20150617.1/0302A/R0/TT

03/02/2016

Business Hub, Fifteenth Ave, West Hoxton - Response to EPA Queries

We have been asked to respond to comments provided by the EPA in their letter of 27 November 2015 with respect to our acoustic assessment of the above site (*Operational Noise Impact Assessment* – dated 1.7.2015, Rev 2).

Noise Logging Data (marked up with Bankstown Airport weather data)

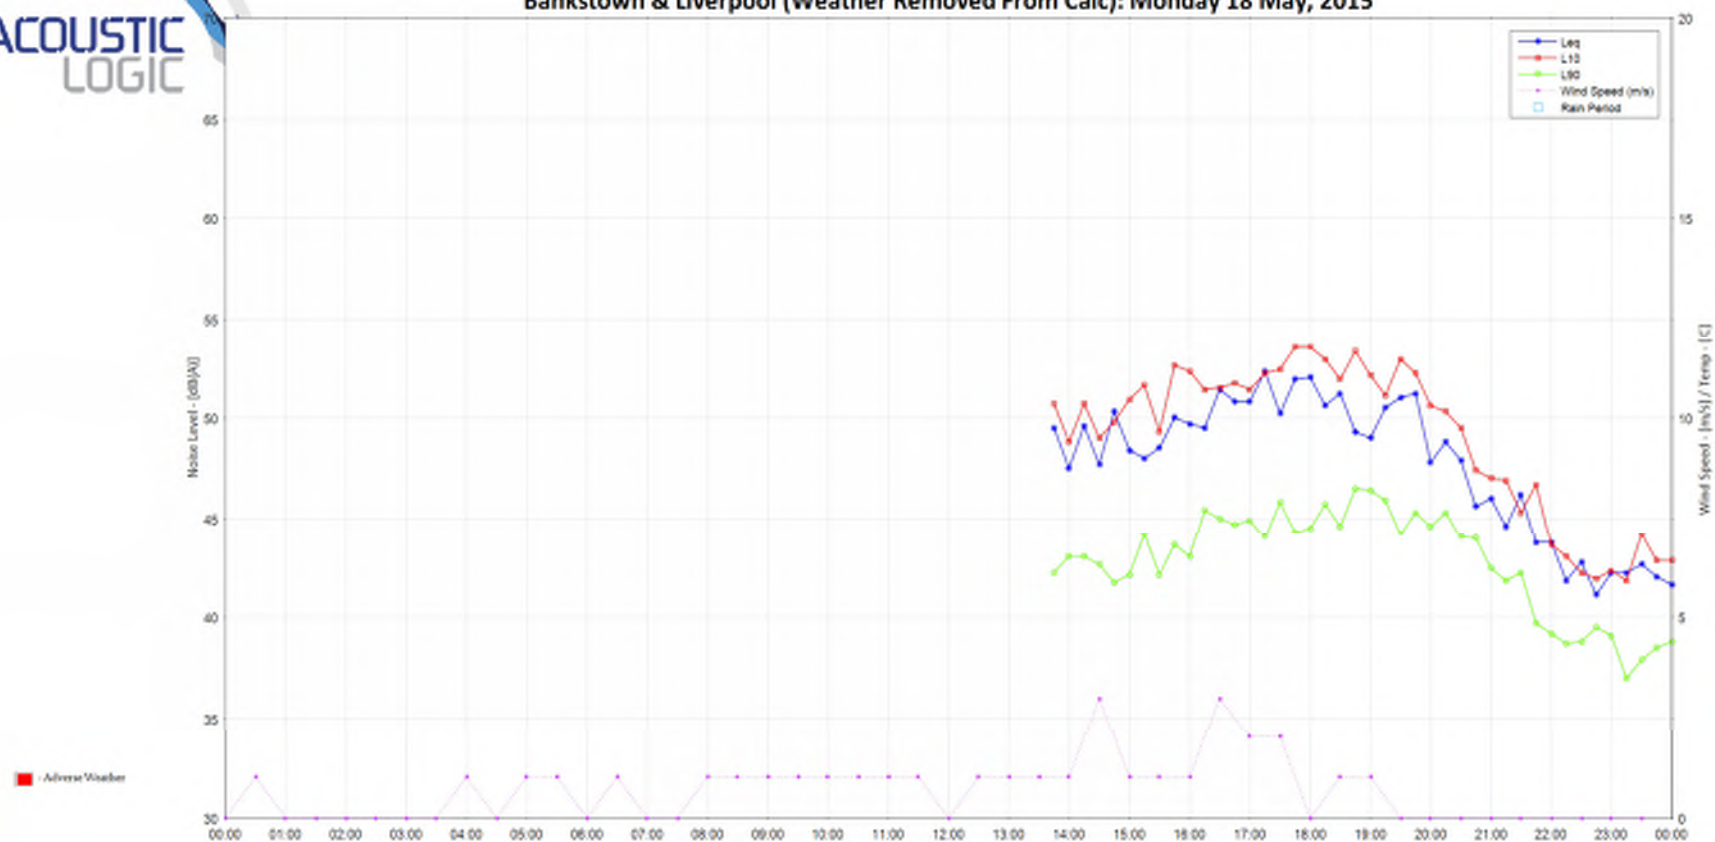
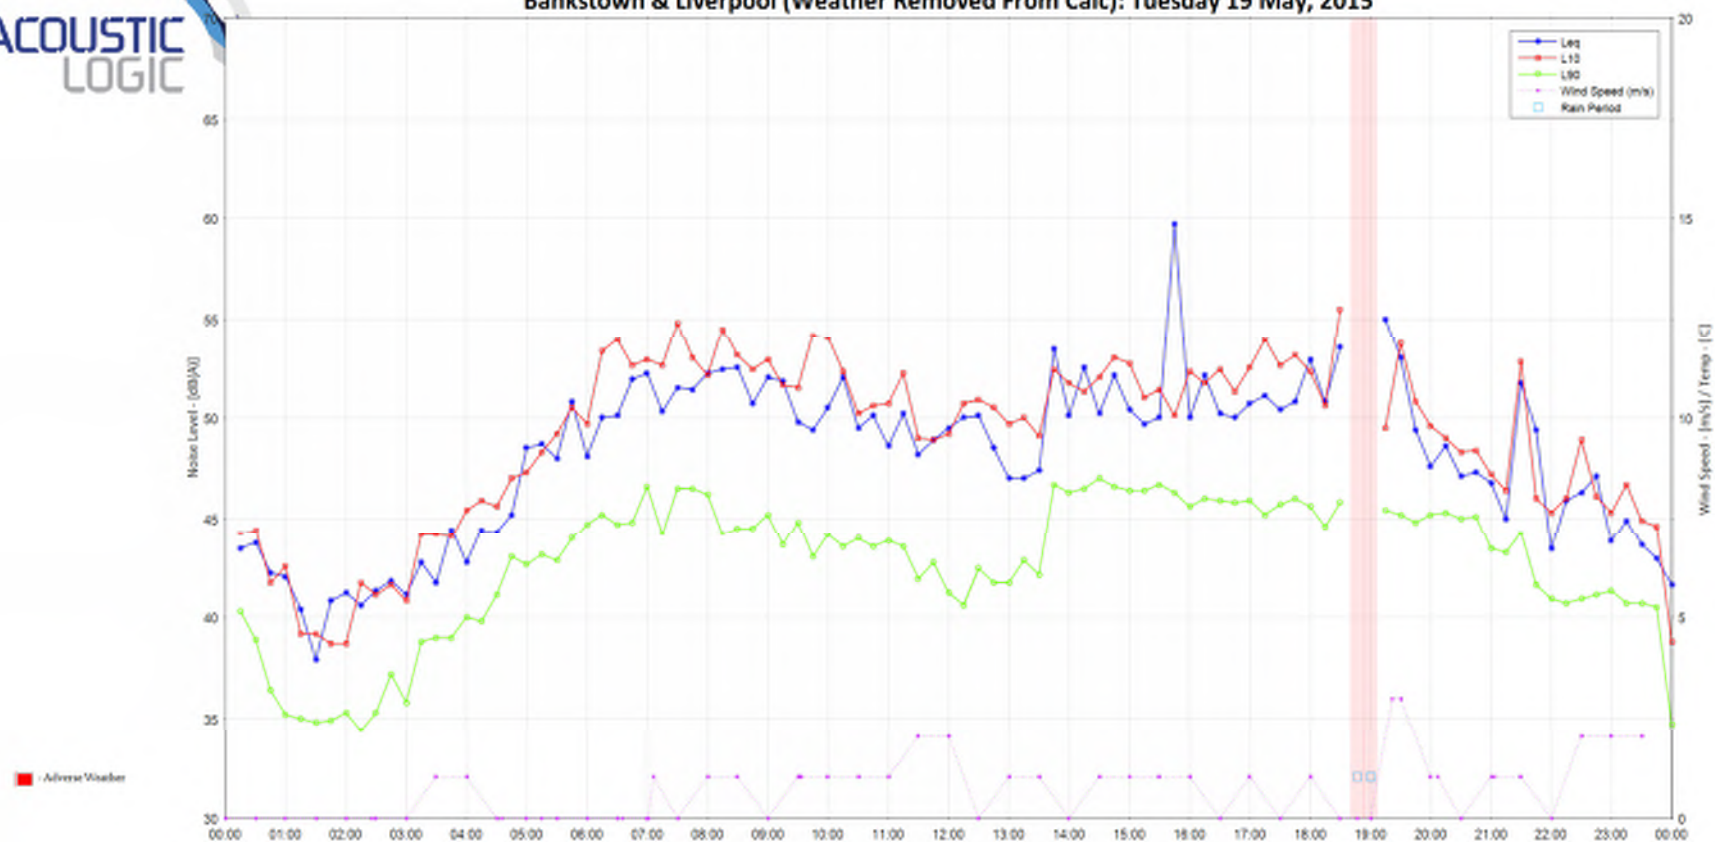
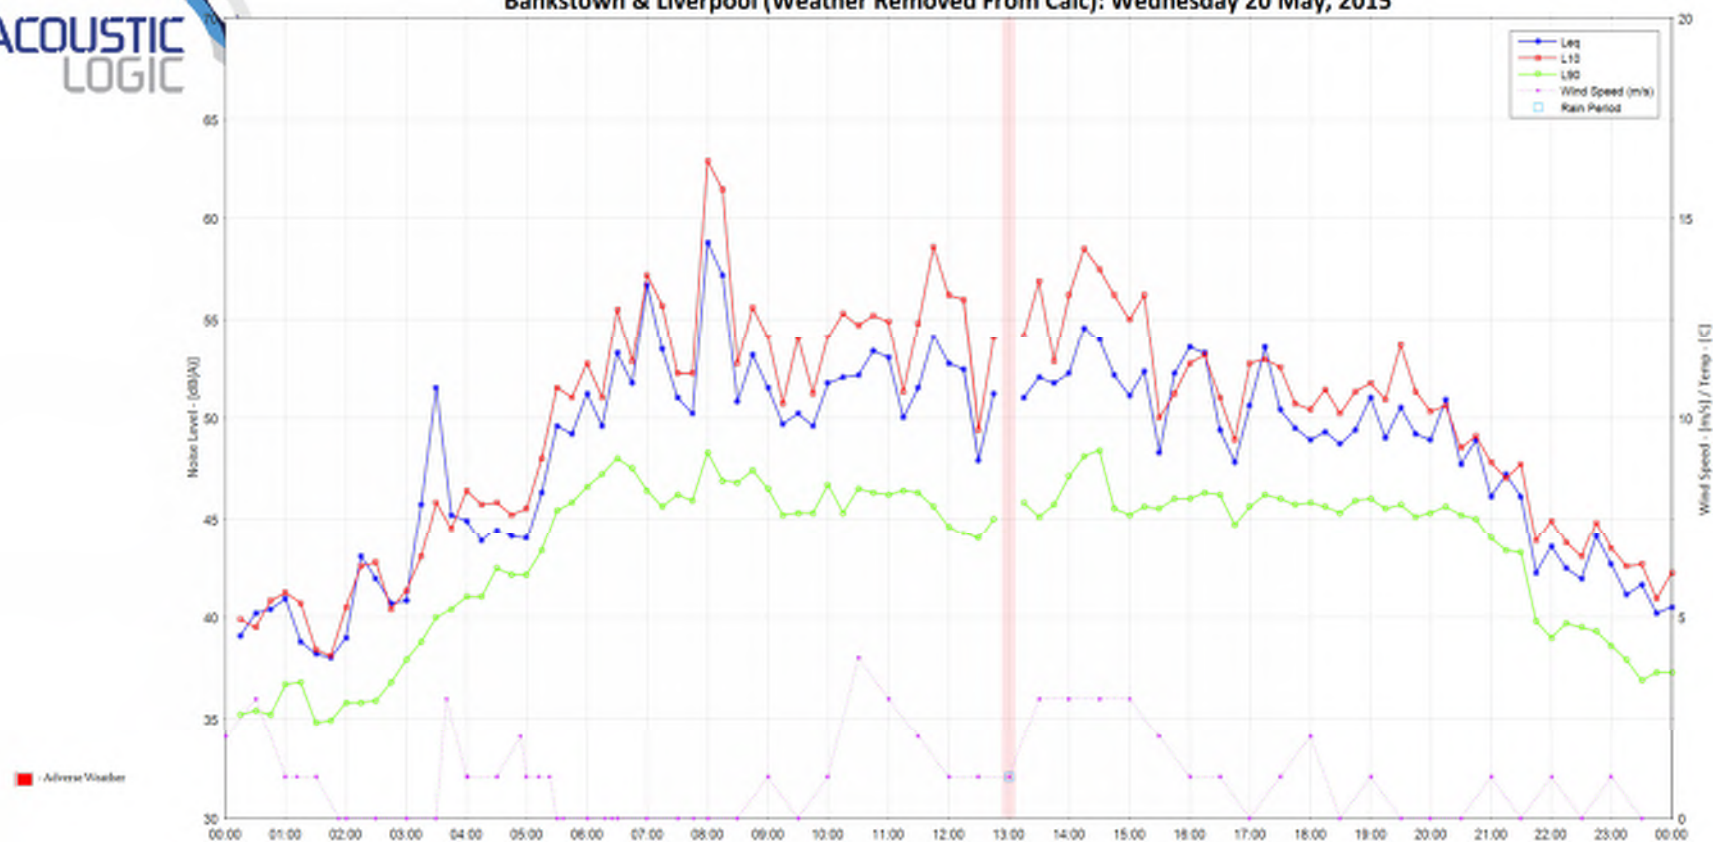
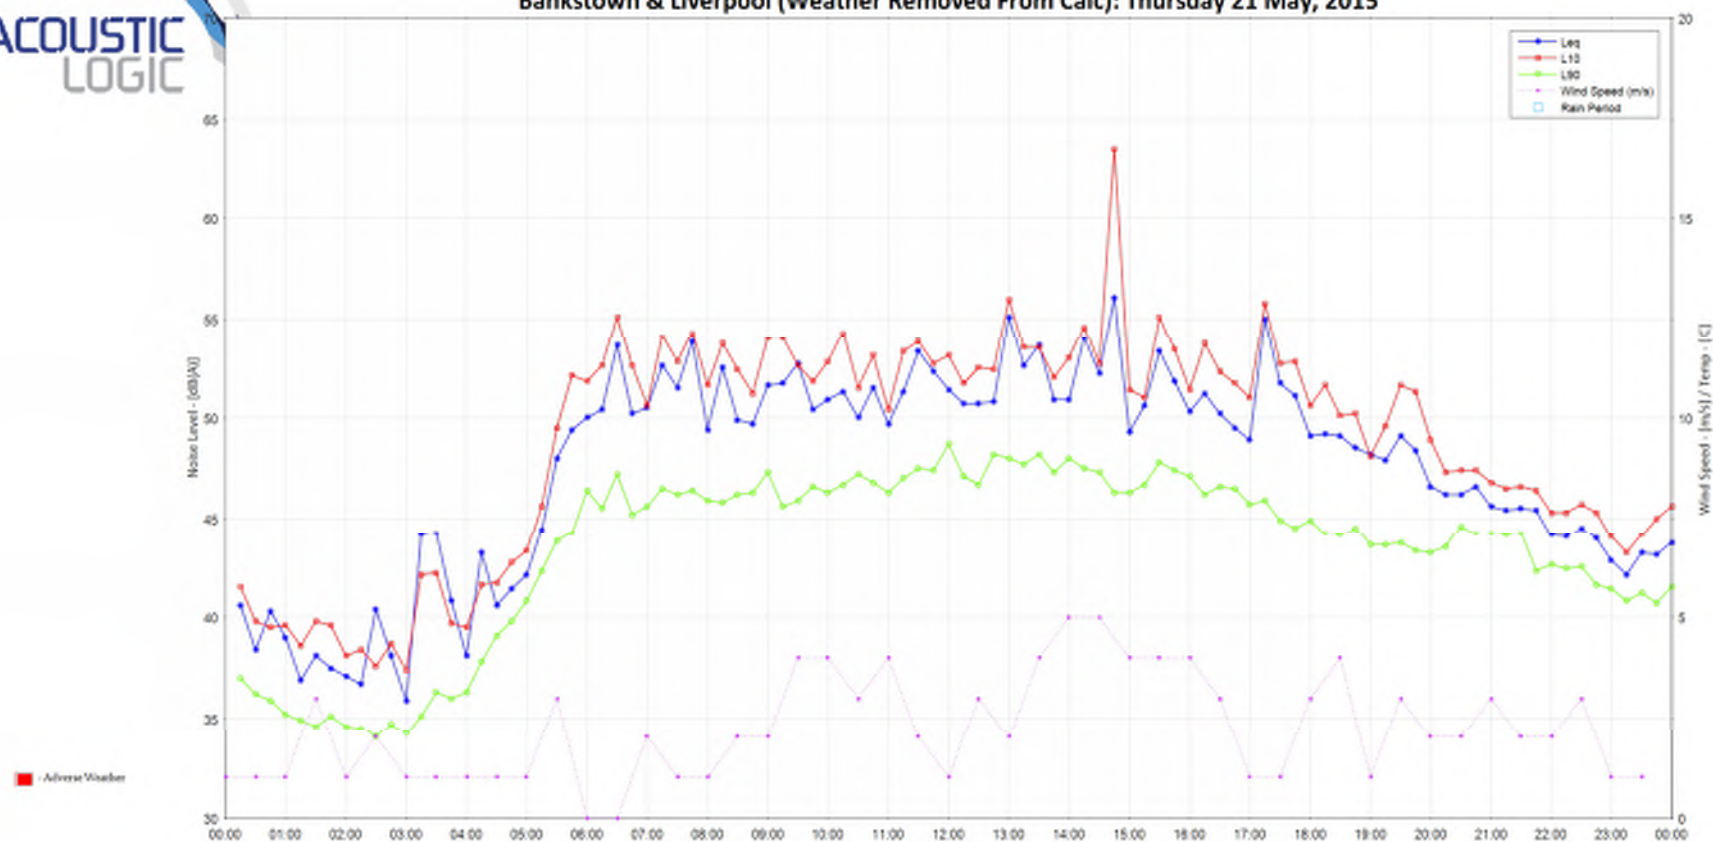
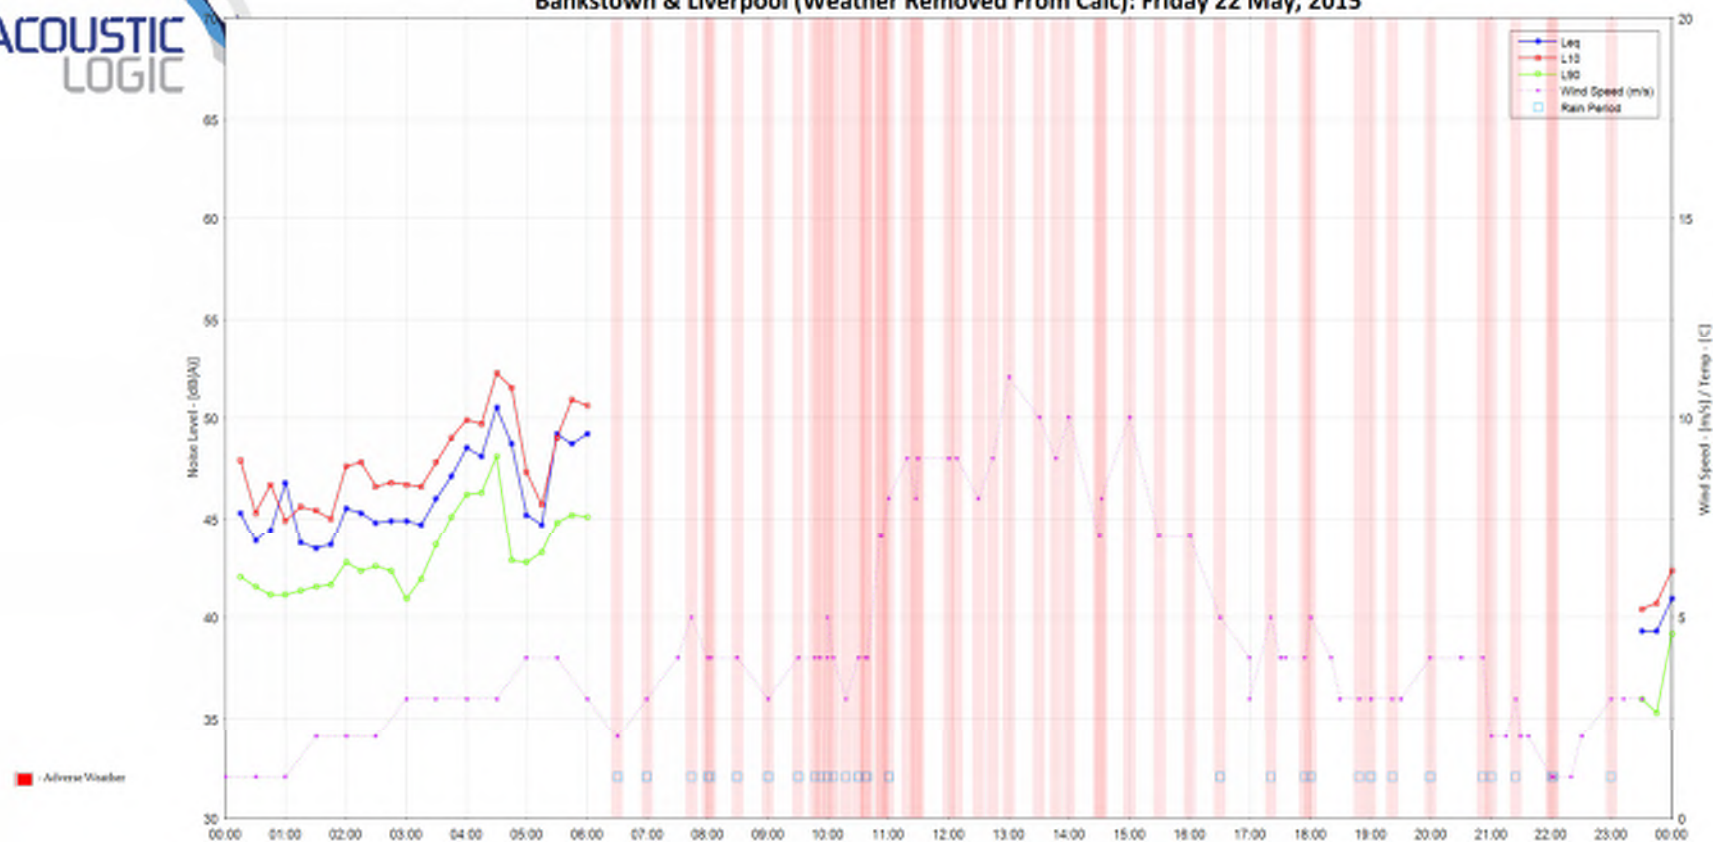
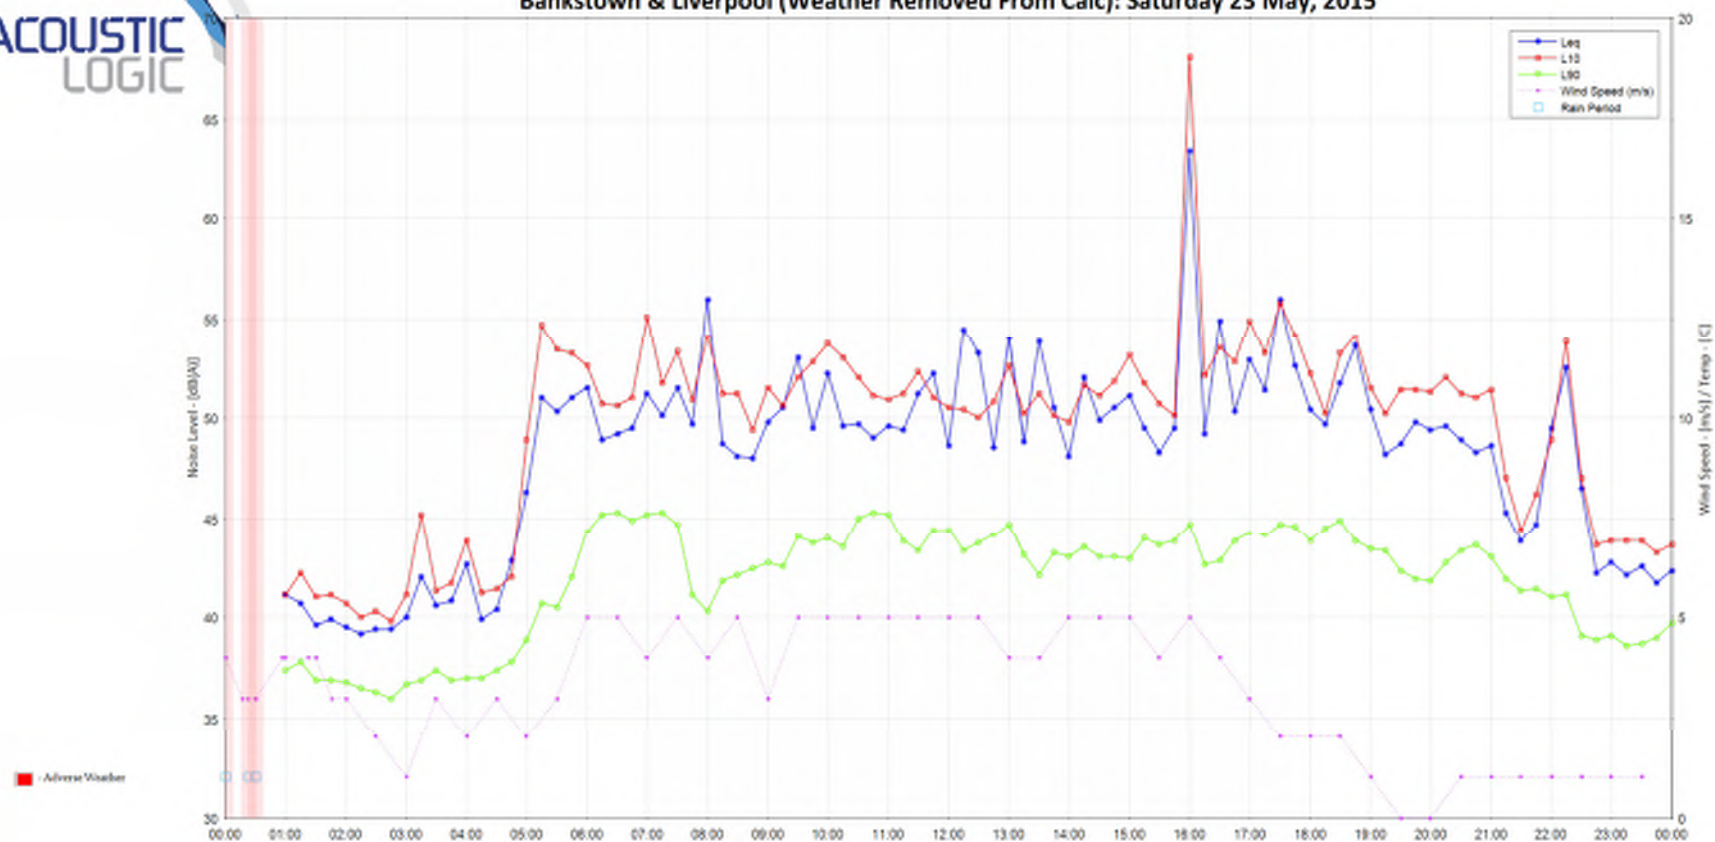
- The fact that metrological data used by them is different to that used by ALC in determining background noise levels in our report.
- The EPA has referred to a number of “wind gusts” which should have resulted in that periods of noise logging being omitted when determining background noise levels.
- The EPA has concluded that due to the fact that there are periods of the logging which are weather effected, that the logging should be re-done.

- With respect to the EPA reference to wind gusts exceeding 18 kilometers per hour on each day from 18 to 23 May, this is in fact irrelevant. Section 3.4 of the Industrial Noise Policy refers to *average* wind speeds for entire 15 minute periods as being the criteria for determining whether that period of data is to be excluded. A short duration wind gust is not relevant, only the average wind speed is. It is the *average* wind speed which was used by ALC in determining Rating Background Noise Levels, which is consistent with EPA practice.

- As a precaution, background noise levels were determined using both the Badgery’s Creek and the Bankstown Airport weather data. The same rating background noise level was determined regardless of the weather data used. Both sets of meteorological data are included in the amended *Operational Noise Impact Assessment*.

- When viewed over an entire one week period, the duration of weather effected data is very small (only one relatively prolonged period with adverse weather occurring during the daytime on 22 May 2015). Other periods were one hour duration or less.

Noise logging data was processed in accordance with EPA guidelines with respect to the impact of adverse weather. The weather data used for assessment was taken from a nearby weather station. Given the overall short duration of weather impacted data, the Rating Background Noise Level used for assessment is accurate.
